LONDON LUTON AIRPORT EXPANSION – DEADLINE 7 SUBMISSION

Project: London Luton Airport Expansion Development Consent Order

Subject: National Highways position on 'Accounting for Covid-19 in Transport Modelling'
(TR020001/APP/8.148)

On Behalf of: National Highways

Figure 1 2043 PM Without Expansion - Updated

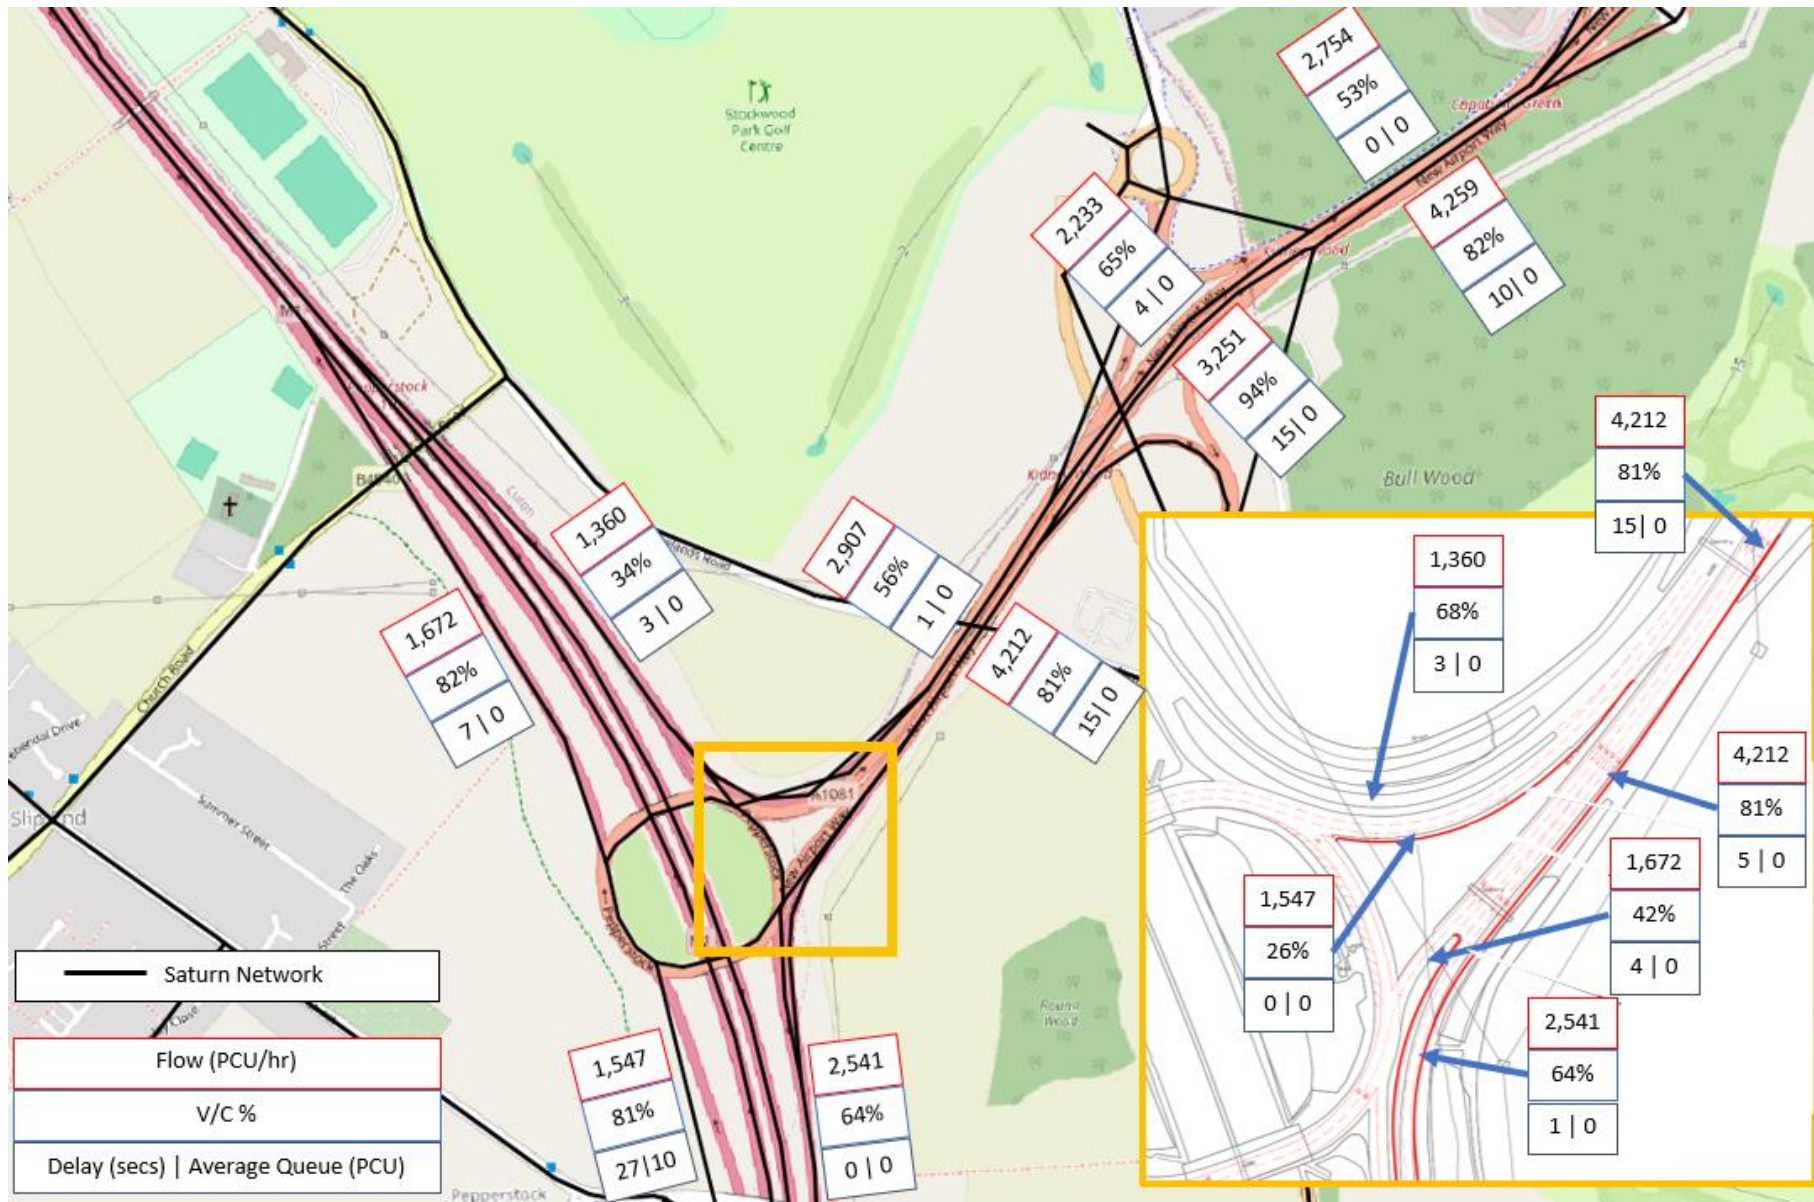
National Highways is concerned about the large differences in flows between with and without airport expansion in 2043 PM peak on the approach arm from the A1081. This could constrain the full traffic demand flow through to M1 junction 10 and result in a large queue on the A1081 approach to the junction during the PM peak period.

Figure 1 on the following page of this submission shows a breakdown of the coding sections of the approaches on the A1081 to M1 junction 10. In the network coding of the A1081 approach to the M1 junction 10, it is interpreted that the A1081 westbound has been represented in small segments in the strategic model with the very last link representing the start of the left-turn free-flow up to M1 junction 10 (section 1) and the link prior to this, representing the straight section of A1081 westbound (section 2).

The ACTMFR shows 2043 forecast year volume over capacity (V/C) ratios for M1 J10 (AM and PM peak periods) (Figure 4-11 in the ACTMFR). On the A1081 westbound, during the PM peak, the V/C ratio for the east right turn decreases from 49% without the airport expansion to 42% with the expansion. The corresponding figures for the east left turn free flow are 77% and 64% respectively.

However, looking at comparisons of traffic flow changes during the PM peak with and without the airport expansion (Figure 1 over the page), for section 1 on the A1081 westbound, the difference is -264 veh/hr and for the link immediately prior to this (section 2) the difference is +864 veh/hr. It is believed that the link V/C ratio as shown in the ACTMFR Table 4-11 relates to section 1 on A1081 rather than section 2.

Furthermore, Appendix F of the ACTMFR, shows the 2043 PM link V/C for A1081 westbound approach to M1 J10, and it indicates section 2 has a value between 80%-90% without the airport expansion and a value of between 90% -100% (ie reaching link capacity level) for the scenario with expansion.

There is a similar pattern and differences in the observed flows on the A1081 eastbound as indicated by sections 3 and 4 in Figure 1 below when compared to the V/C ratios in the ACTMFR Figure 4.1 1 and Appendix F.

An explanation is required on the reasons for the differences in the flows and V/C ratios on the SRN. Further, as indicated in Section 2.2 of this Technical Note, it is requested that the applicant provides further information on queues and delays on all sections of the A1081 approach to/from the M1 junction 10, to provide a more comprehensive understanding of traffic conditions on the approach to junction 10. Unless the provision of such information is deferred, National Highways are unable to determine the full development impact. The ExA will also require this information to inform its recommendation.

Figure 3 Without Expansion Demand Model Convergence

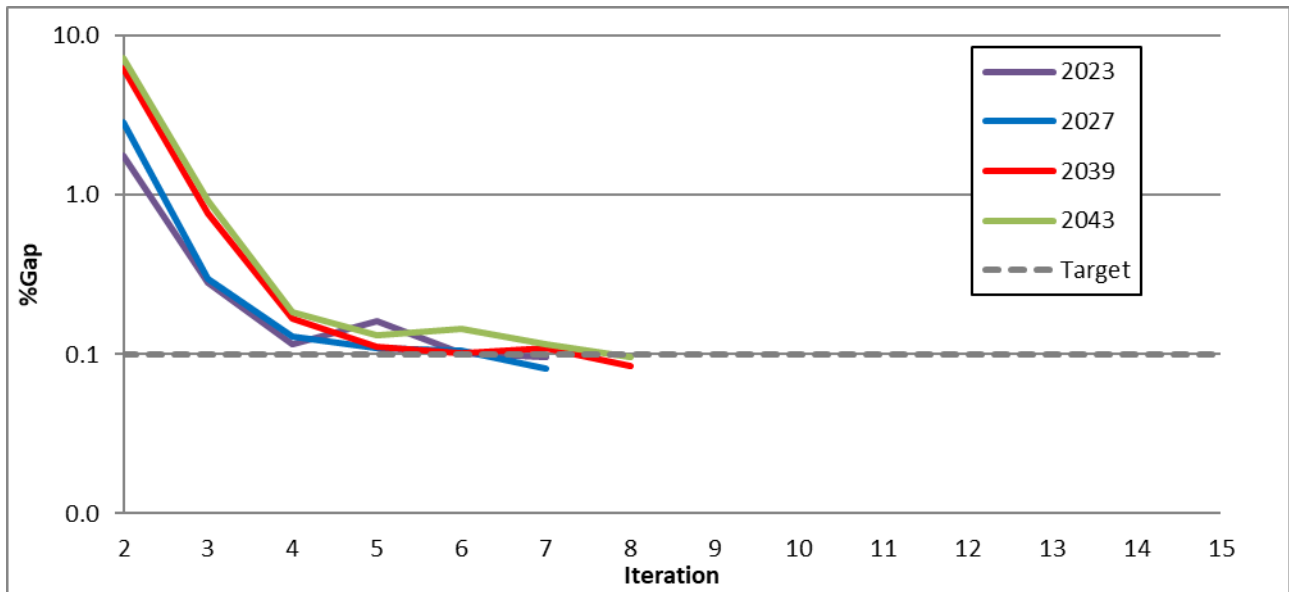
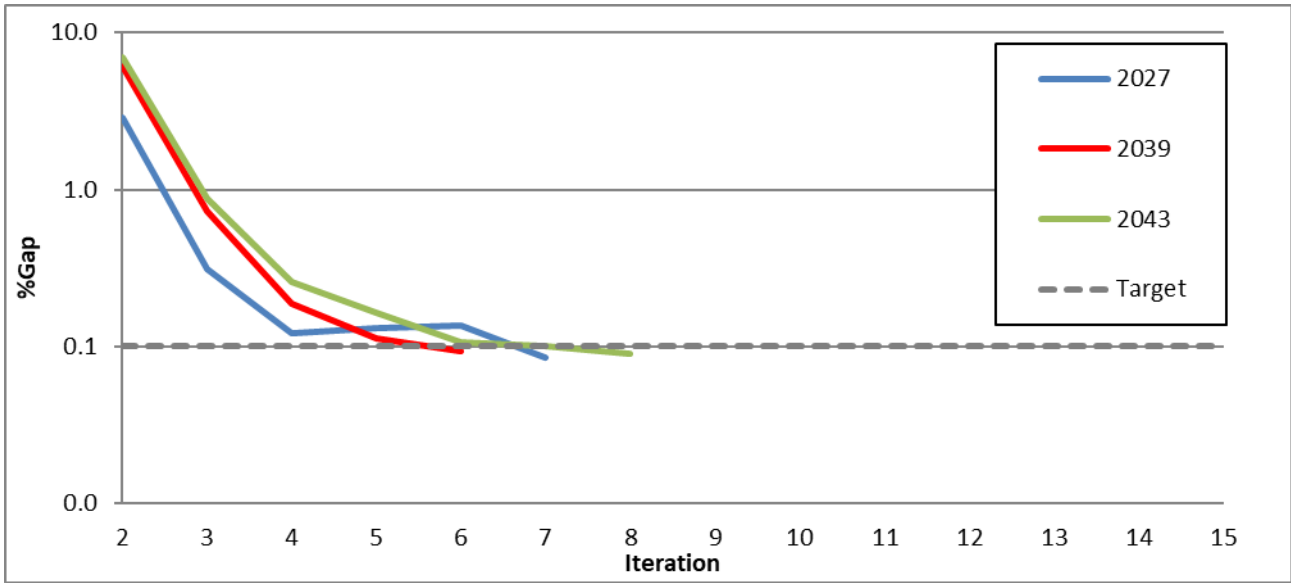
No information on the model convergence has been provided within ACTMFR. According to TAG Unit M 3.1, model convergence is required to provide stable, consistent and robust model results and to differentiate real changes due to the assessment scheme and those associated with 'noise' in the model. Table 4 in TAG unit M3-1 recommends the following criteria for Wardrop User Equilibrium assignment to ensure a satisfactory model convergence:

- **Delta** – should be less than 0.1%, or at least stable, with convergence fully documented and all other criteria met. Delta is the measure of convergence of the final assignment to ensure that the alternative routes used in the assignment process do not differ significantly from the final minimum cost. It is the difference between costs on the various multiple assigned routes and those along the final minimum cost routes, as a percentage of minimum cost routes;
- **Flow change (P)** – should be less than 1% for four consecutive iterations for 98% of links. P is the measure of convergence of assignment – simulation loops. It is the percentage of links where assigned flows change by less than 1% between successive assignment simulation loops; and
- **Wardrop Equilibrium** - assignment percentage gap function should also be low as <0.05 for 4 consecutive loops.

For each forecast year and each peak period, it is requested that the Applicant provides the above information, to ensure the figures presented in ACTMFR are based on a fully converged model and to give National Highways confidence in the modelling outputs. Unless the provision of such information is deferred, the ExA will also require this information to inform its recommendation.

Figure 5 Location of southbound merge markers

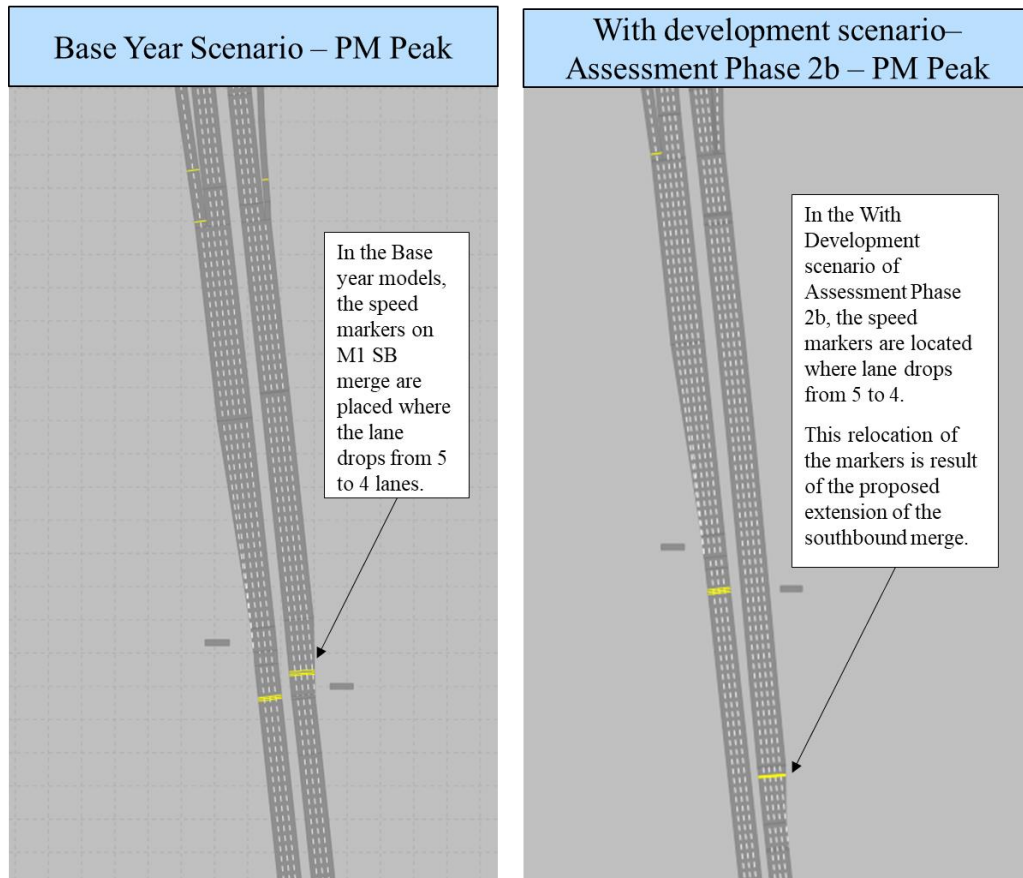
However, for future phases of development, we remain concerned about residual congestion on the southbound merge and in relation the operation of the northbound mainline, with a particular problem where the 5 lanes reduce to 4, north of Junction 9. Due to the scenarios modelled, and some of the methodology, we cannot be
